Our ref: DOC21/809851

Presentation to Heritage Council meeting of 6 October 2021 by Department of Planning, Industry and Environment (DPIE) on the State Significant Development (SSD) Glendell Continued Operations Project relating to Ravensworth Homestead

Thank you for your request dated 14 September 2021 inviting further comments from the Heritage Council of NSW on new information in relation to the economic viability of the Glendell Mine provided by your independent experts for the above State Significant Development (SSD-9349) proposal.

Figure 16: 500m Homestead Offset Conceptual Final Landform

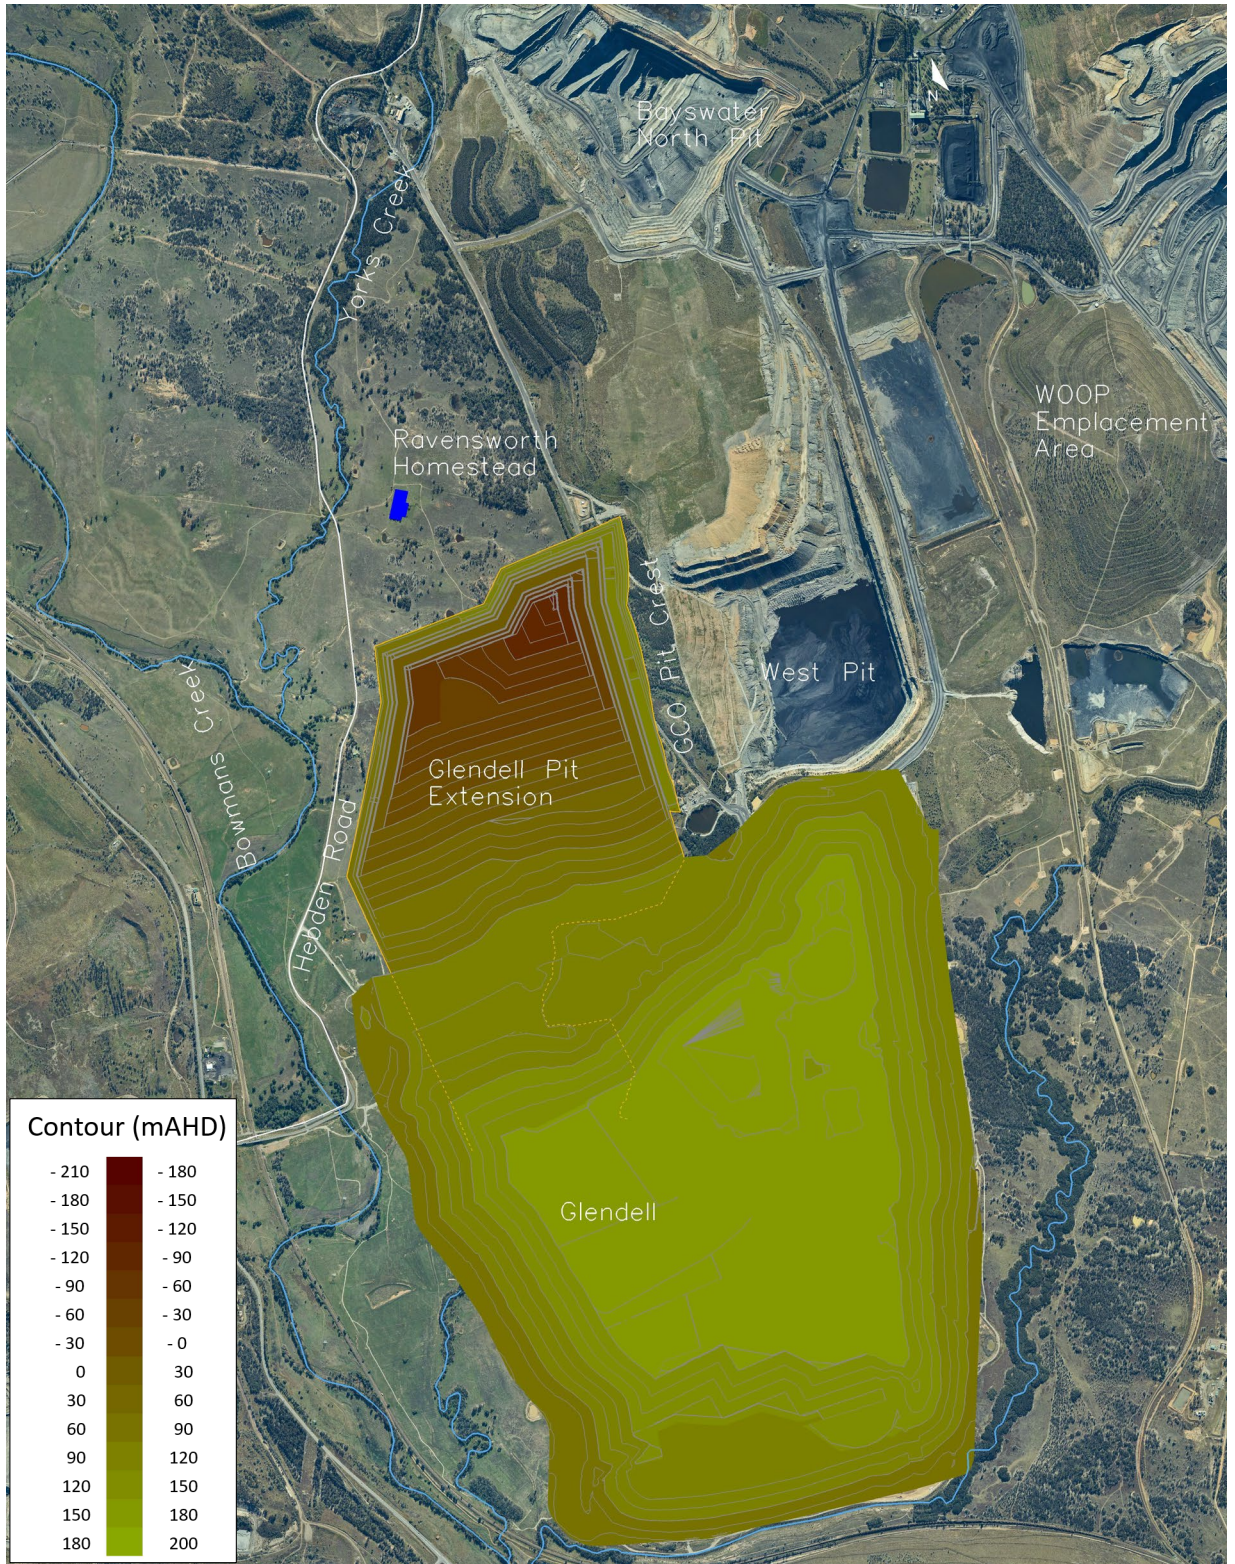
1. The analysis of mining options does not provide a full analysis of an option for a 200m-300m buffer zone as proposed by Mine Craft Consulting.

2. Request an analysis of a staged approach that would:
 - a. Approve a mining plan with a less than 500m buffer zone, allowing coal to be accessed south and east of the homestead.
 - b. Add mitigation measures from blast and vibration, including a berm or blast barrier and structural vibration supports sufficient to preserve all the buildings.
 - c. Allow further stages to be revisited in 2030 - 35, that could access the resource on the north of the site should it prove economically viable at that time, to be valued as an option (with the relocation of the homestead)
